Document title: EIA Addendum

Client	WuXi Biologics Ireland Limited
Project	Effluent Balancing And Resource Recovery System
Job number	100085897

As requested by LCC, recommended design changes and mitigation measures featured in this report have now been incorporated into the refined design layout. All revised planning drawings are presented in Appendix 1.3.

FIRE TENDER MANOEUVRE INTO SITE
SCALE N.T.S.

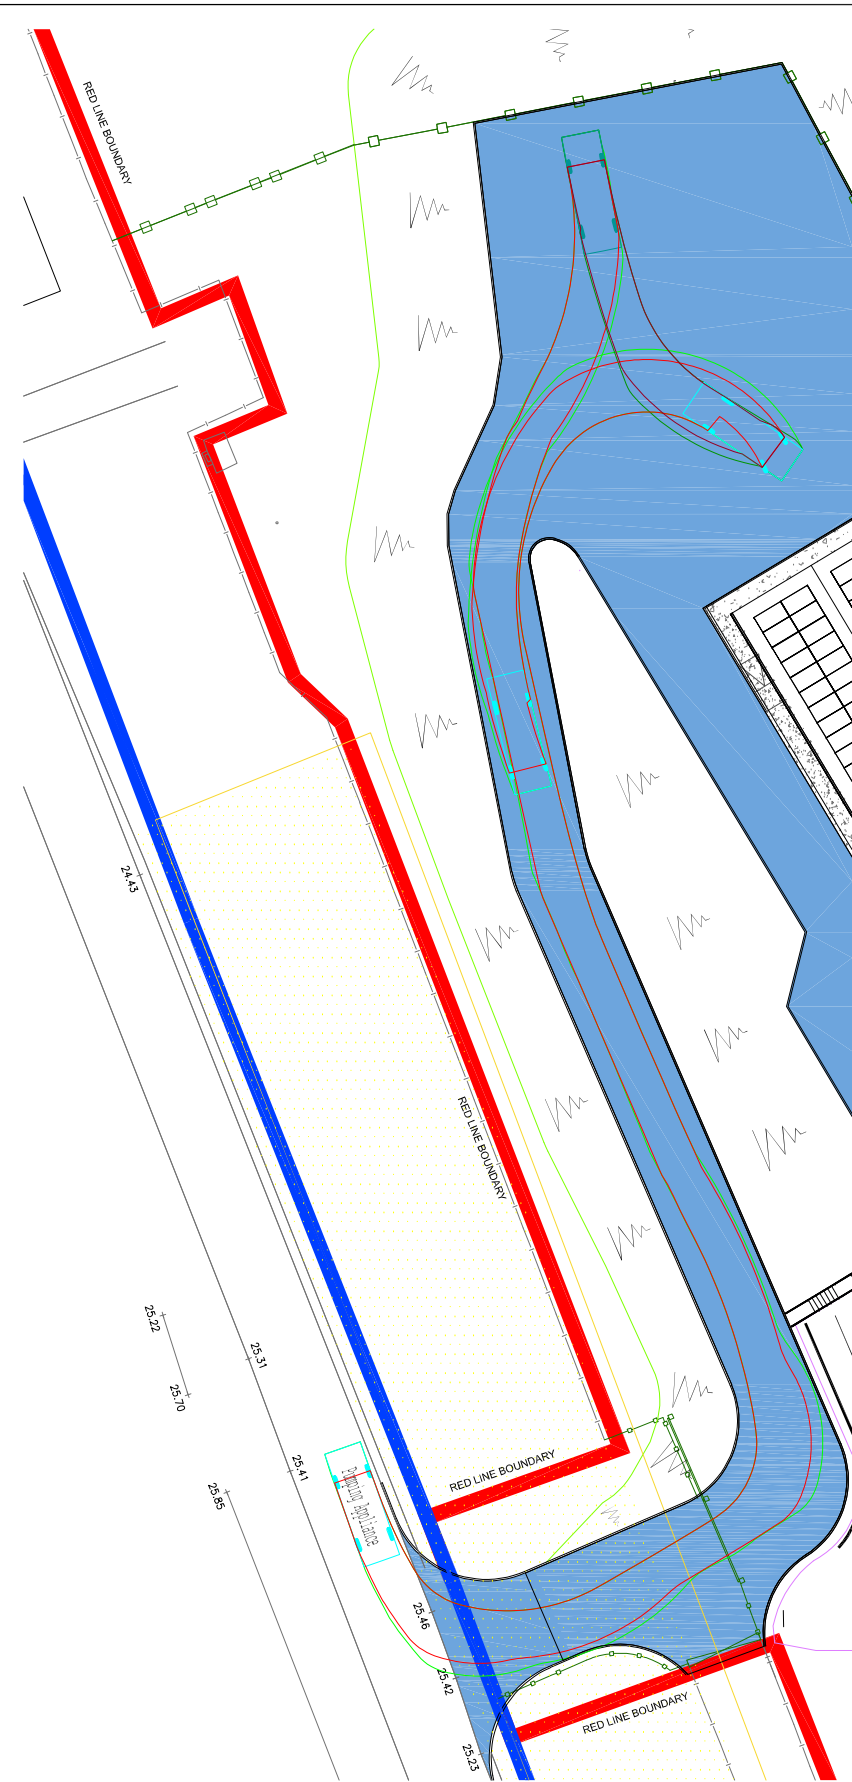
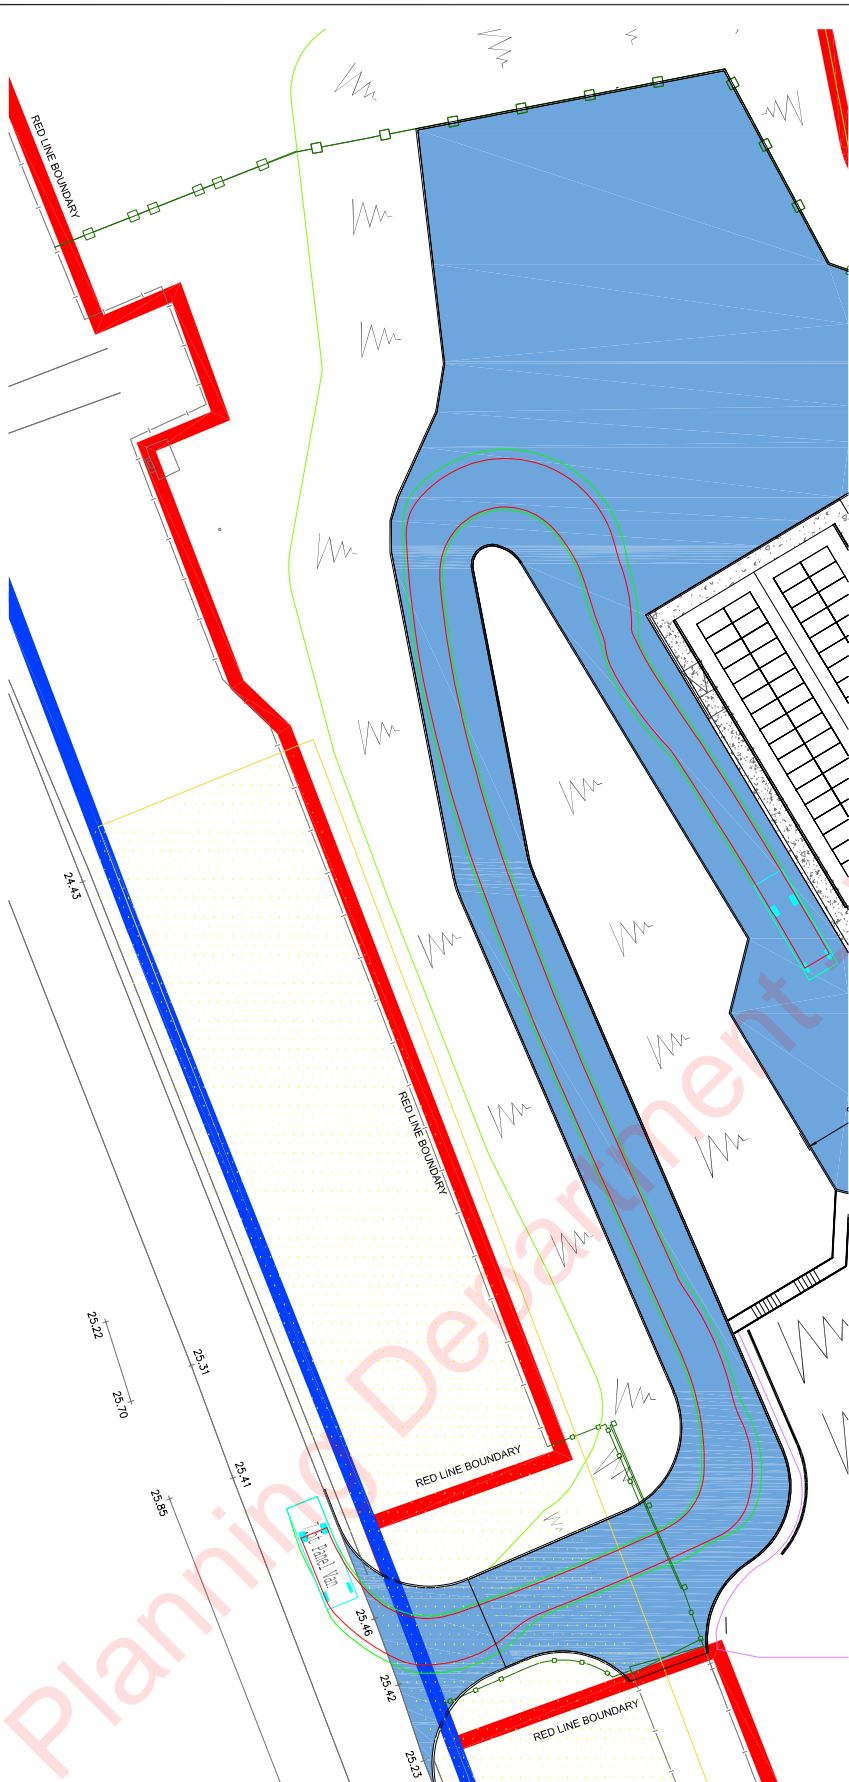
The fire access road has been moved further south in line with the reduction in the bund footprint. Drainage calculations have been reviewed and refined as a result. Refer to the revised drainage calculations submitted separately as part of this FI response.
